Your Ref: BR/82/22/PL

**RE: Holmlea, Main Unit Rear of Town Cross Avenue Bognor Regis PO21 2DN**

Thank you for your correspondence of the 11<sup>th</sup> April 2022, advising me of a planning application for demolition of warehouse and proposed construction of 10 self-contained apartments. This application is in CIL Zone 4 (Zero Rated) as flats at the above location, for which you seek advice from a crime prevention viewpoint.

Proposed Apartments
Planning

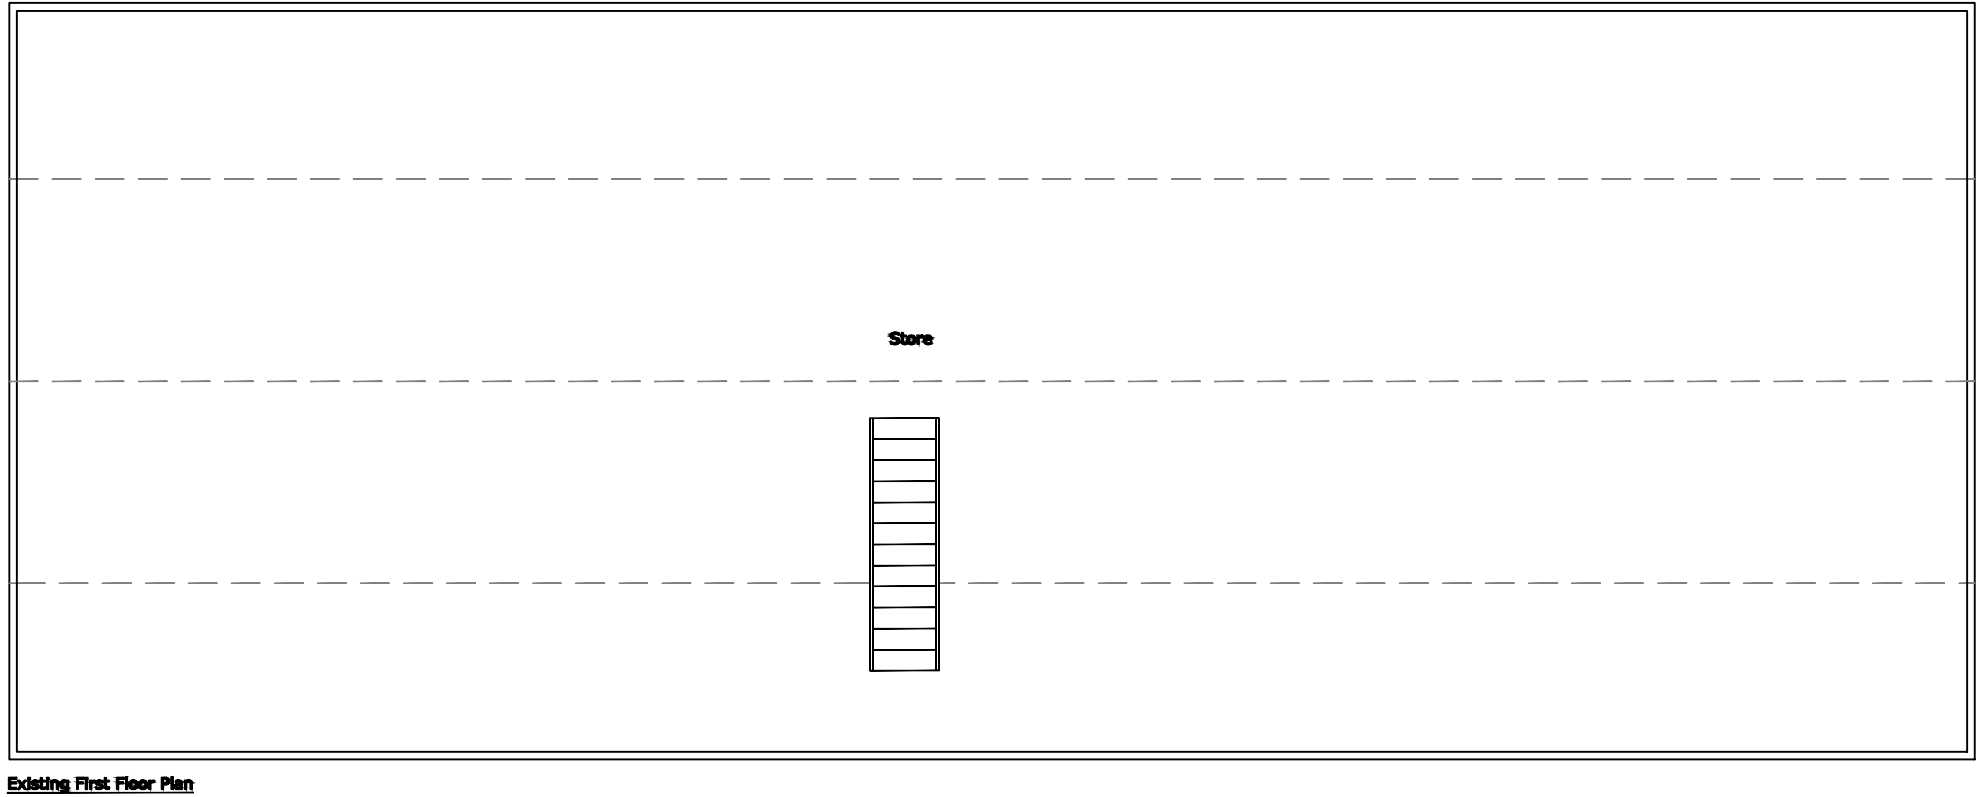
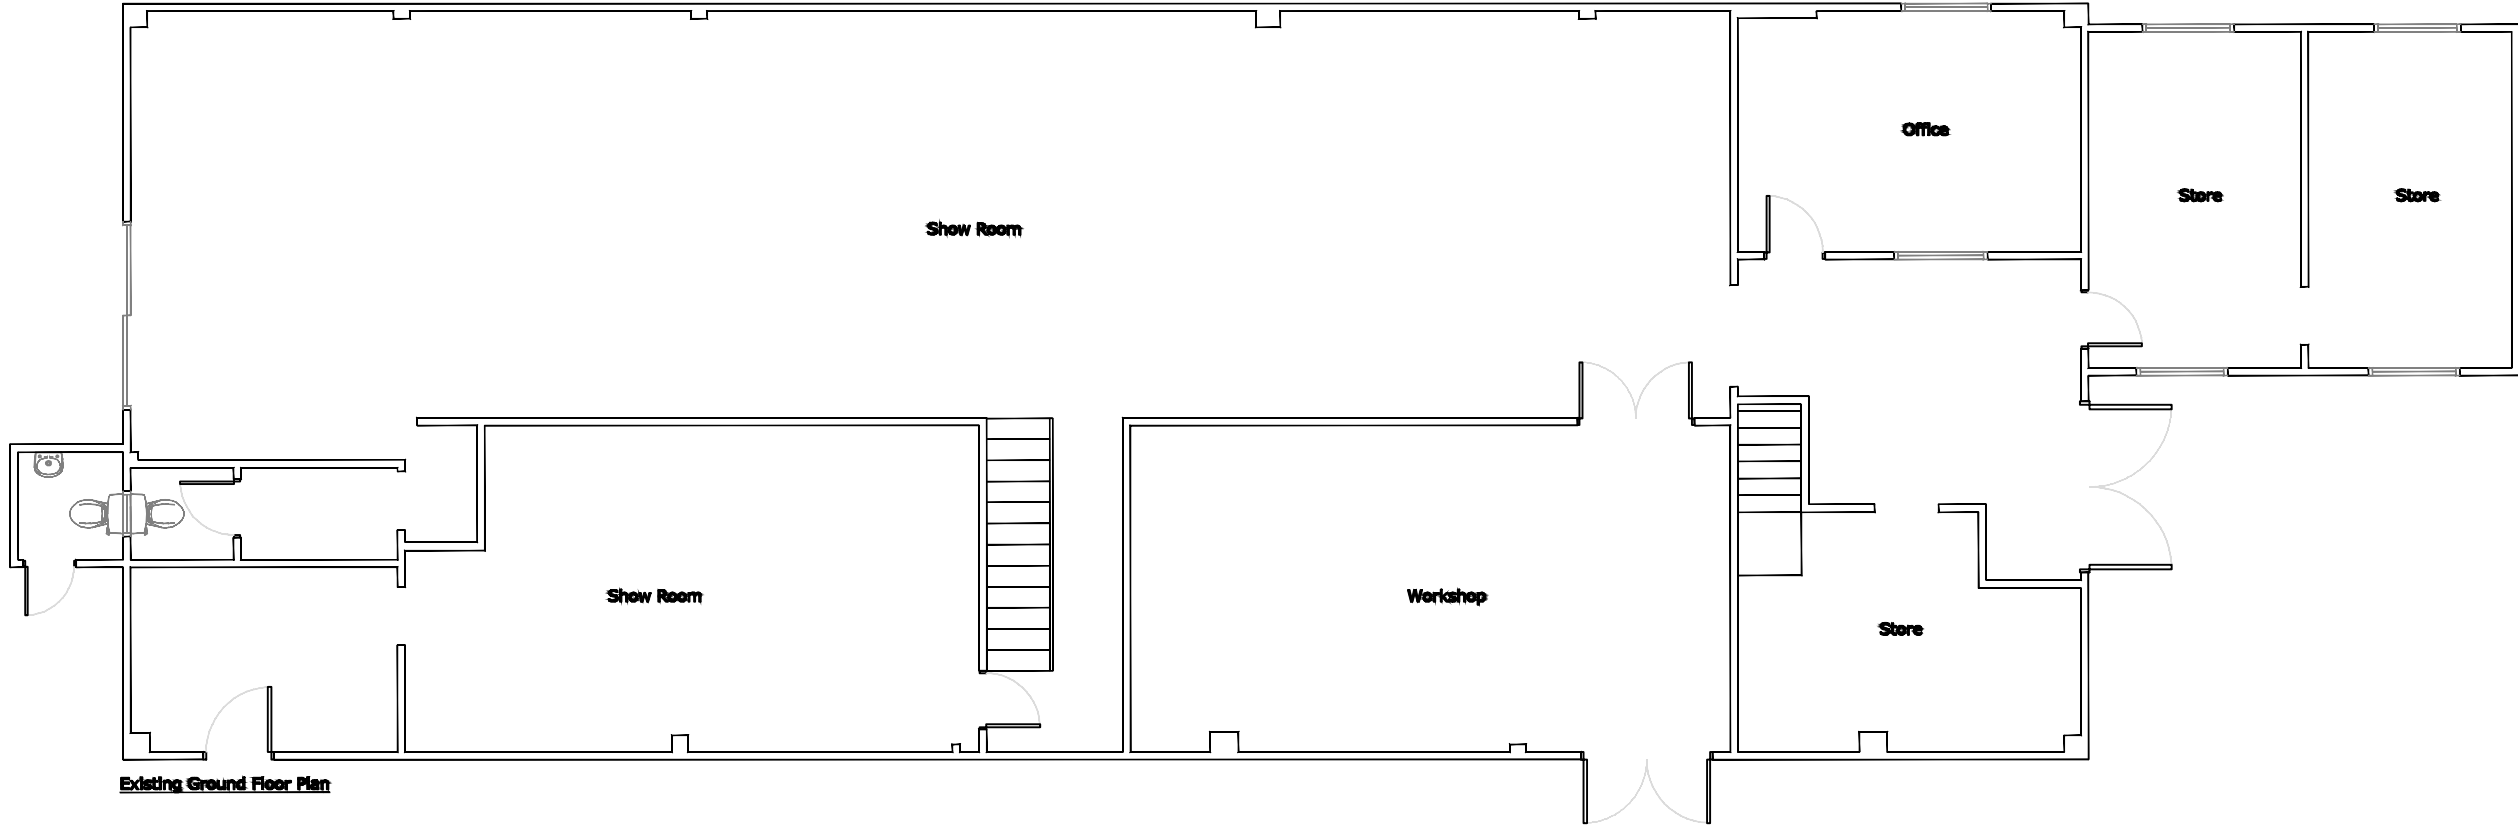
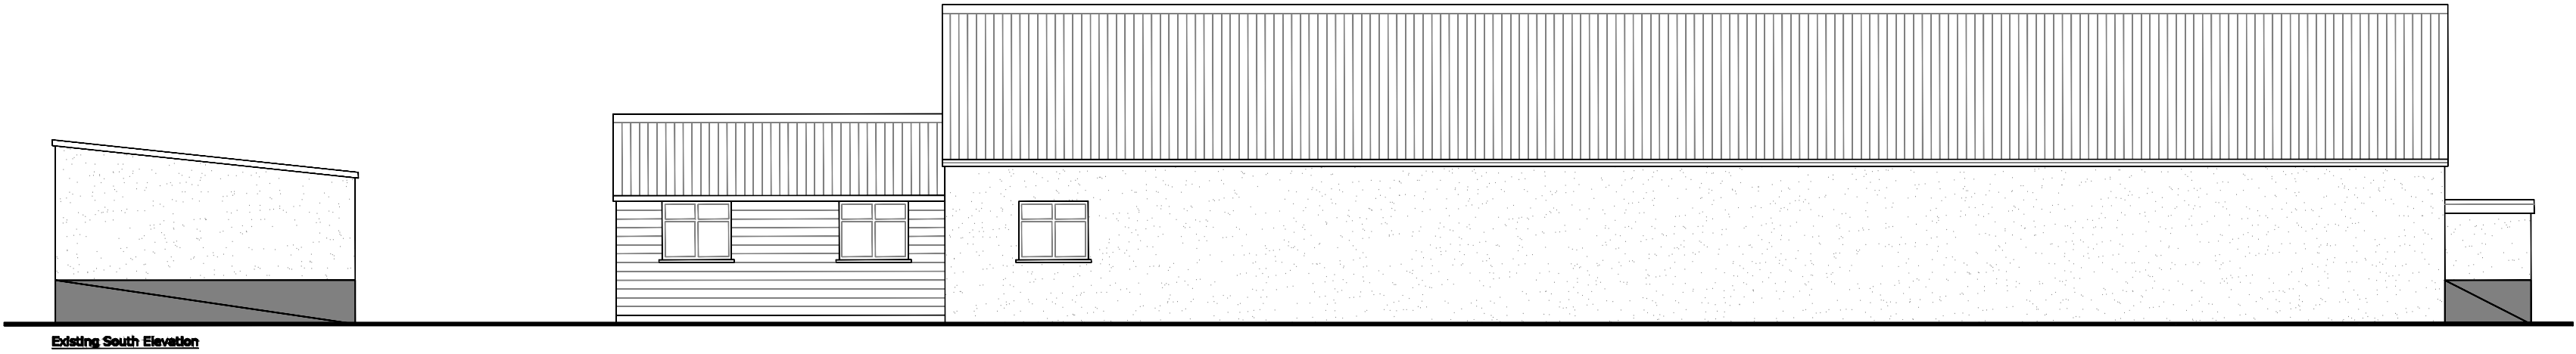
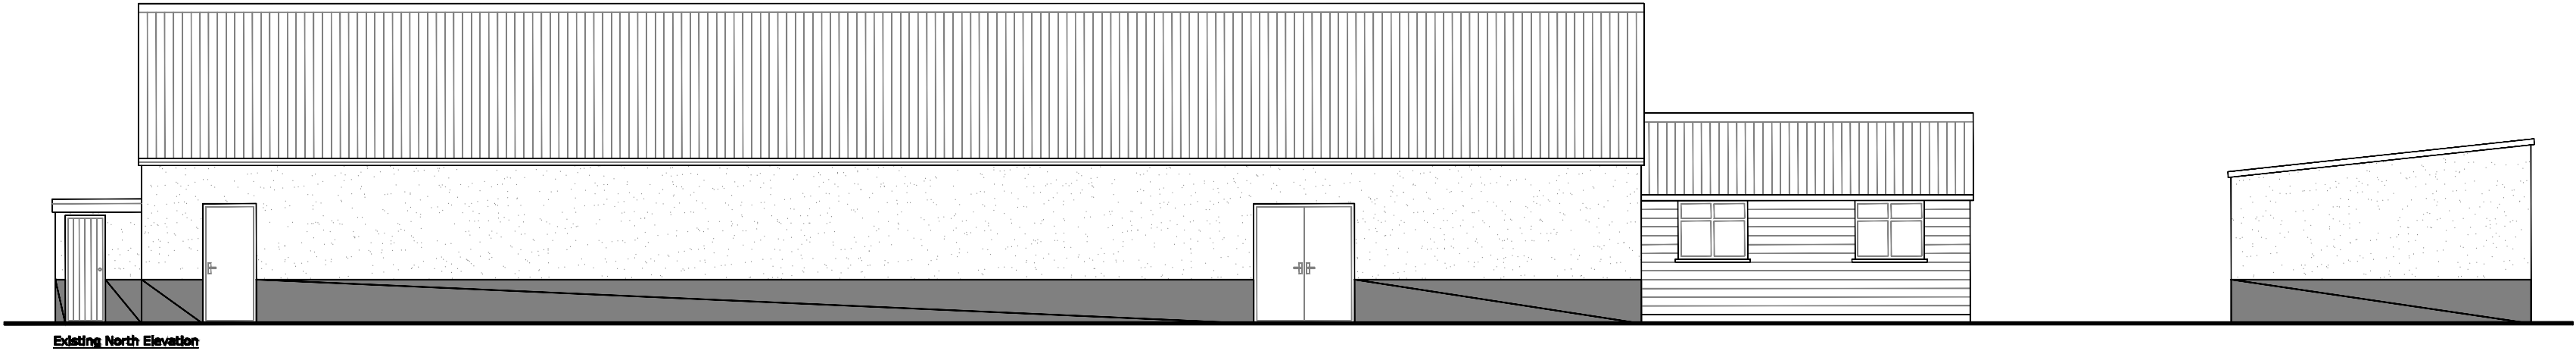
From a crime prevention perspective with regards to the proposed apartments, it will be imperative that access control is implemented into the design and layout to ensure control of entry is for authorised persons only. Trades person or timed-release mechanisms are not advised as they have proven to be the cause of antisocial behaviour and unlawful access to communal developments. For additional information I refer the applicant to chapter 27 of the SBD Homes Document Version 2 2019.

Additionally, I recommend the postal arrangements for the apartments is through the wall or externally mounted secure post boxes. I strongly urge the applicant not to consider letter apertures within the apartment front doors. The absence of the letter aperture removes the opportunity for lock manipulation, fishing and arson attack and has the potential to reduce unnecessary access to the block.

Where communal parking occurs, it is important that they must be within view of an active room within the property. An active room is where there is direct and visual connection between the room and the street or the car parking area. Such visual connections can be expected from rooms such as kitchens and living rooms, but not from bedrooms and bathrooms.

With regards to any proposed landscaping - ground planting should not be higher than 1 metre with tree canopies no lower than 2 metres. This arrangement provides a window of observation throughout the area.
